Rev A	05/10 Additional Highway Comments added
Rev B	Updated Miller Comments 25.01.21

KMC Comment	Miller Comment
Access		
1A	- o Junction modelling input files to be provided for review; - o Collision analysis to be provided for review; - o Clarification of on-site parking provision is required, with amendments required to address any shortfall in provision; - o Amendments to the site access and internal layout are required to address PROW, HDM and Highway Design comments. In particular, the treatment of the affected PROW through the site needs further consideration; - o Updated Swept Path Analysis (SPA) is required of the amended site layout, which must be undertaken in accordance with local guidance; - o Detailed plans are required to confirm how all highway adoption standards are being met, including visibility requirements, and must clearly demonstrate the proposed adoption extents; - o Stage 1 Road Safety Audits are required for the S278 and S38 works.	- o ATTP have provided the junction modelling within Rev A of the TA. - o ATTP have provided and reviewed the collision analysis within Rev A of the TA. - o Car parking has been provided in accordance with SPG. - o Existing PROW

SCALE @ A3: 1:250	CHECKED: AT	APPROVED: AT
CAD FILE: 18001_SPA_001	DESIGN-DRAWN: TS	DATE: 23/02/22
PROJECT No: 18001	DRAWING No: 18001/SPA/104	REV: C

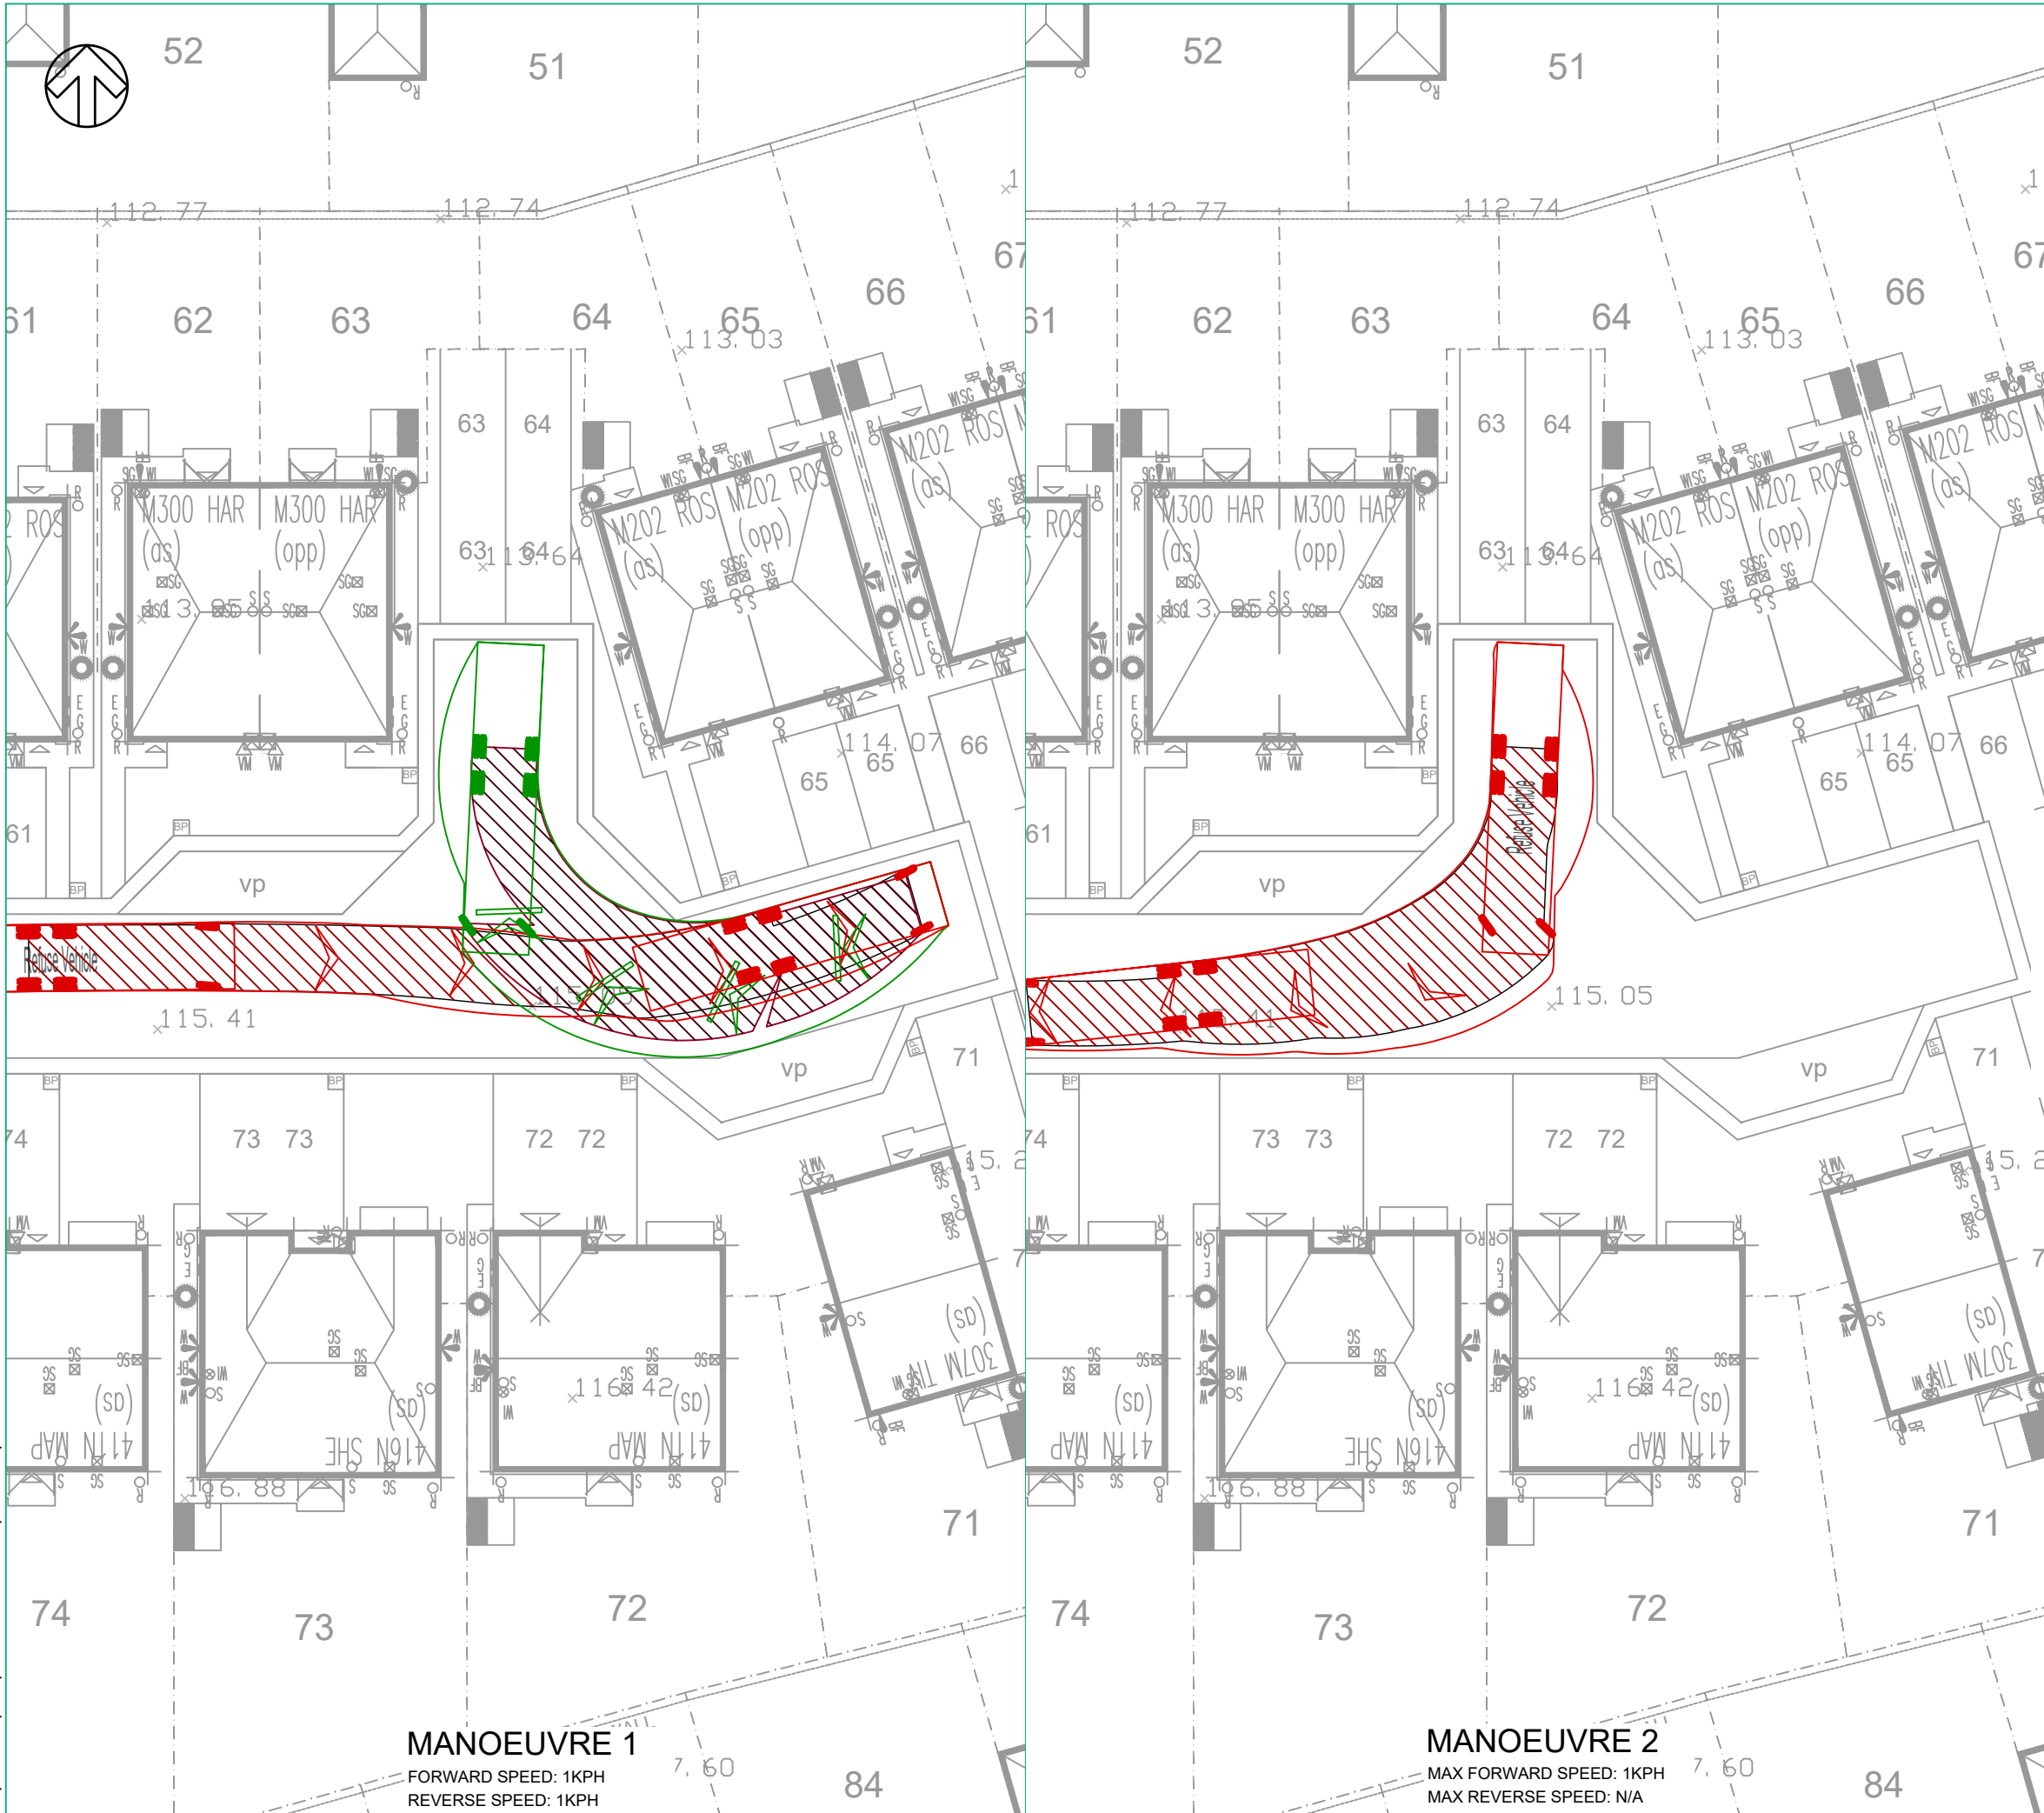
19	xii. Where on-street parking is envisaged, swept path analysis is required to demonstrate if the Kirklees Refuse Vehicle can manoeuvre through;	o ATTP have provided updated swept path analysis within Rev A of the TA.
20	xiii. No swept path analysis (SPA) drawings have been provided for our assessment for the development layout. The current development proposal shown strongly indicates issues with refuse vehicle manoeuvrability;	o ATTP have provided updated swept path analysis within Rev A of the TA.
21	xiv. SPA is required on all turning head areas and severe bends to optimise their size in relation to refuse vehicle movements;	o ATTP have provided updated swept path analysis within Rev A of the TA.
22	xv. On all turning heads it is required to demonstrate using swept path analyses that when manoeuvring, Refuse Collection Vehicles, shall be able to travel at a minimum speed of 5 km/h. In other words, drivers shall not need to stop to adjust the steering while stationary before setting off again. The Kirklees vehicle parameters are set out in Table 1 of Emergency Access, Waste Management, Servicing & Deliveries - April 2020 (version 1): - - o Length – 11.85 m - o Width – 2.50 m (including wing mirrors) - o Width when loading – 4.10 m - o Working height – 6.00 m - o Turning circle (wall to wall) – 22.07 m (diameter) - o Turning circle (between kerbs) – 17.88 m (diameter) - o Gross vehicle weight – 32 t.	o ATTP have provided updated swept path analysis within Rev A of the TA.

24	xvii. Around tight bends in the carriageway consideration should be given to making provisions for overrun areas or localised carriageway widening where required following SPA checks;	o ATTP have provided updated swept path analysis within Rev A of the TA. The site layout as proposed accommodates vehicular manoeuvres.
25	xviii. To transition from the widened existing tarmacked road to the proposed Section 38 block paved road a ramp should be introduced that should be no steeper than 1:12;	o Added to the site layout accordingly.
26	xx. Around bends SPA for two normal size vehicles being able to cross each other in the contraflow direction needs to be demonstrated too;	o ATTP have provided updated swept path analysis within Rev A of the TA. The site layout as proposed accommodates vehicular manoeuvres.
27	xxi. Around tight bends in the carriageway consideration should be given to making provisions for overrun areas or localised carriageway widening;	o ATTP have provided updated swept path analysis within Rev A of the TA. The site layout as proposed accommodates vehicular manoeuvres.
